CITY OF PORTLAND

BUILDING PERMIT

Job ID: 2012-11-5371-ALTR

has permission for an addition of 22' by 22' attached garage (Single Family Residence).

4' Frost wall 18/10 footing

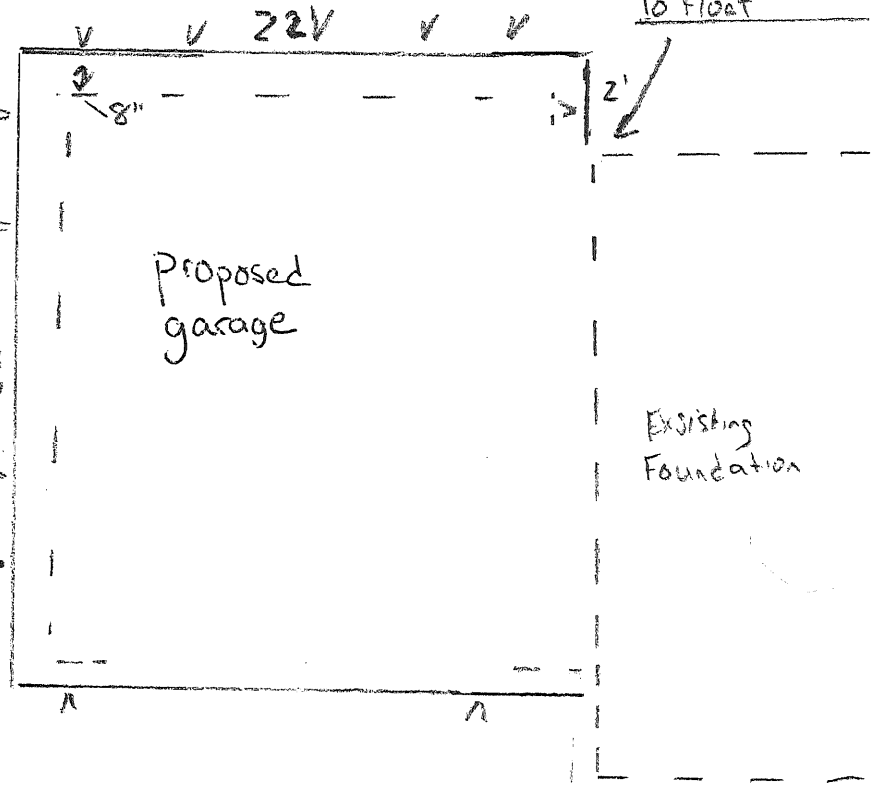
2. Frost protection must be installed per the enclosed detail as discussed w/owner/contractor (at least 4' from grade).
3. Section R317 Protection of Wood and Wood Based Products against decay. All wood framing members that rest on concrete or masonry exterior foundation walls and are less than 8 inches from the exposed ground.

# Framing plane

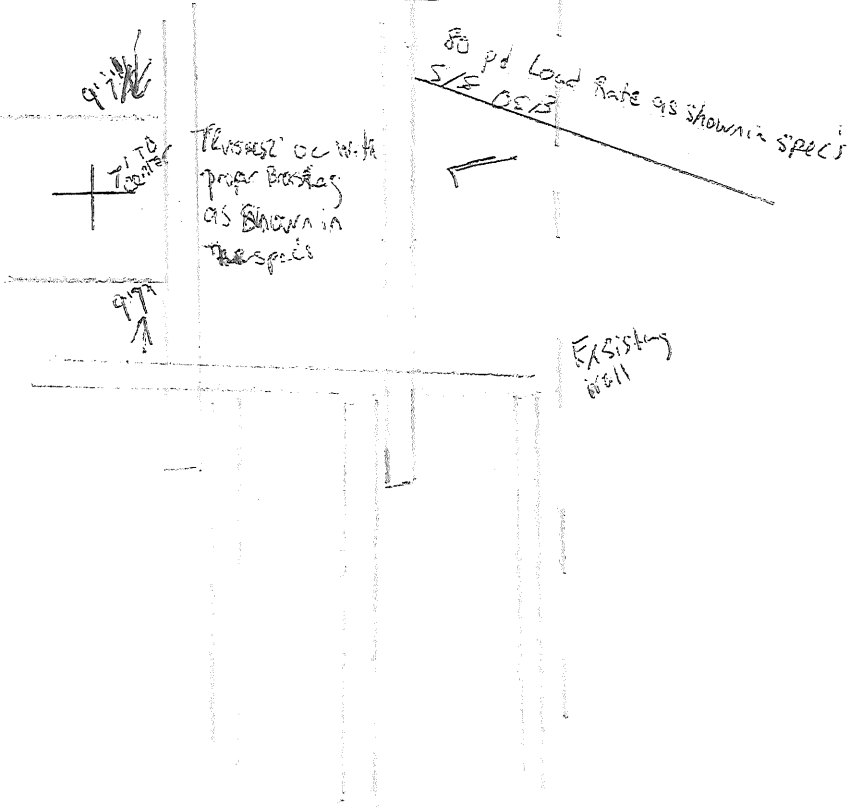
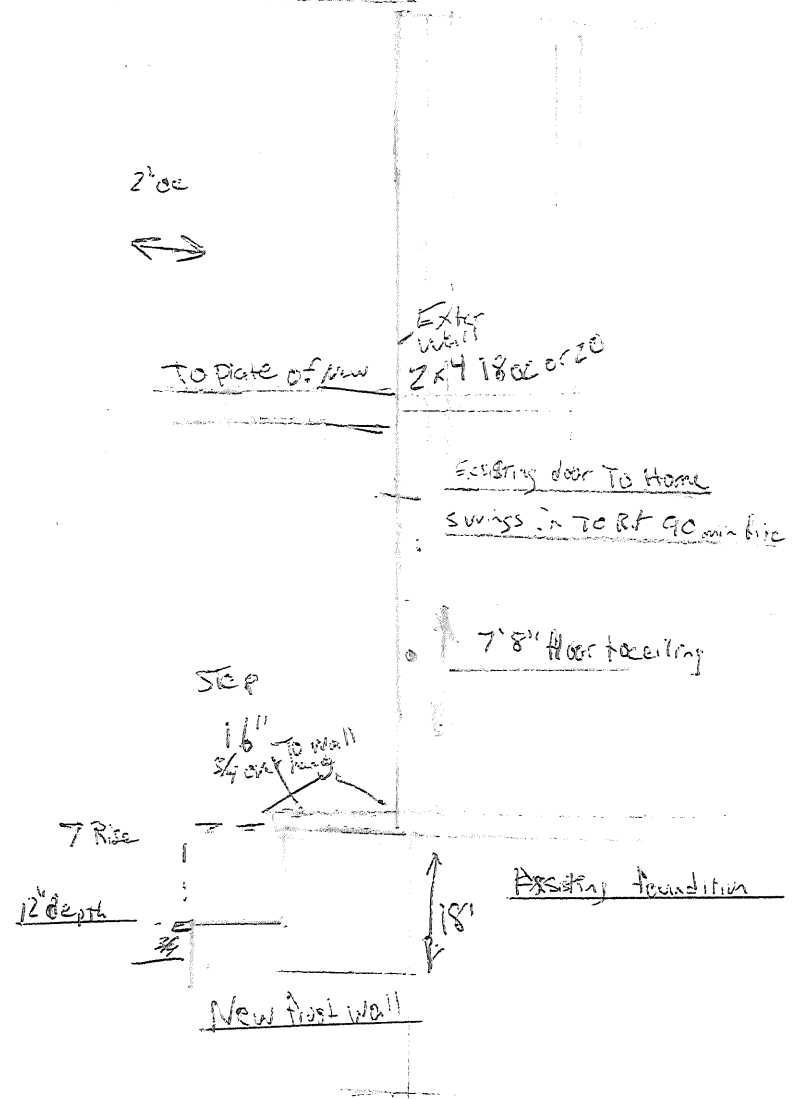
5. R807.1 Attic access. Buildings with combustible ceiling or roof construction shall have an attic access opening to attic areas that exceed 30 square feet and have a vertical height of 30 inches or greater. The vertical height shall be measured from the top of the ceiling framing members to the underside of the roof framing members. The rough-framed opening shall not be less than 22 inches by 30 inches and shall be located in a hallway or other readily accessible location.

New Door TO BE installed For Entry

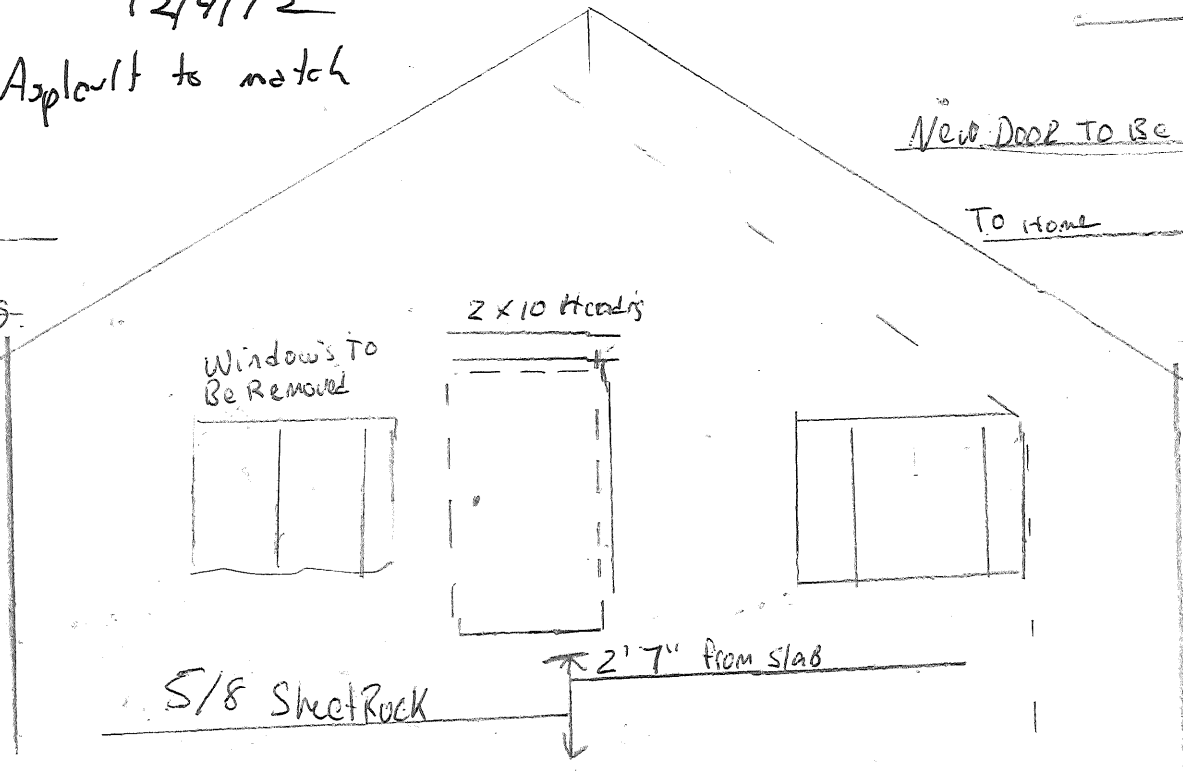
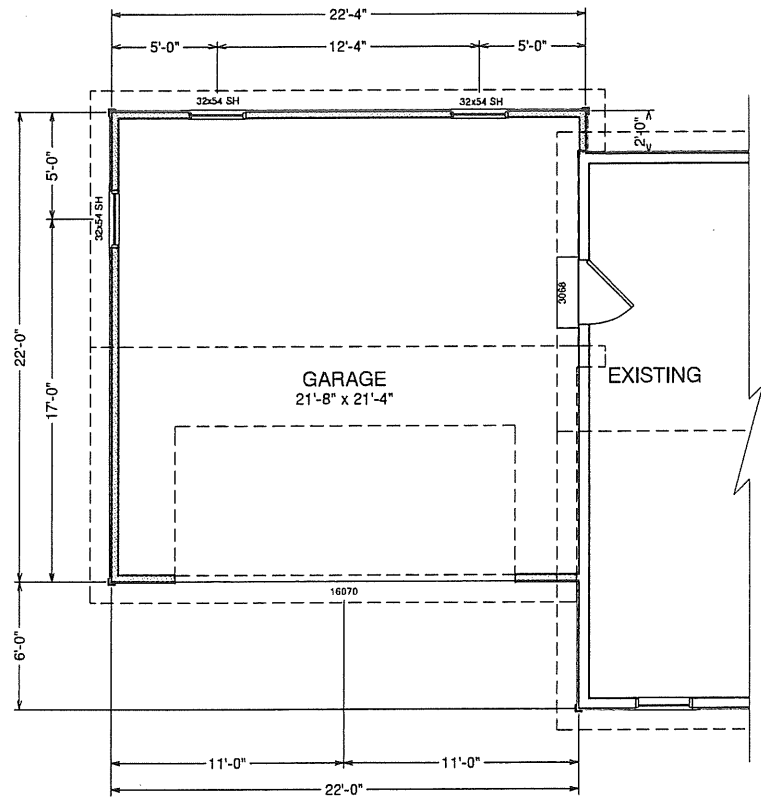
6. The door opening between the garage and residence shall be equipped with solid wood doors not less than 1 3/8" inches in thickness, solid or honeycomb core steel doors not less than 1 3/8 inches thick, or 20-minute fire-rated doors.
7. Note: Submit specifications for engineered trusses & beams to this office prior to construction.

**TABLE R302.6
DWELLING/GARAGE SEPARATION**

SEPARATION	MATERIAL
From the residence and attics	Not less than 1/2 inch gypsum board or equivalent applied to the garage side
From all habitable rooms above the garage	Not less than 5/8-inch Type X gypsum board or equivalent
Structure(s) supporting floor/ceiling assemblies used for separation required by this section	Not less than 1/2 inch gypsum board or equivalent
Garages located less than 3 feet from a dwelling unit on the same lot	Not less than 1/2-inch gypsum board or equivalent applied to the interior side of exterior walls that are within this area
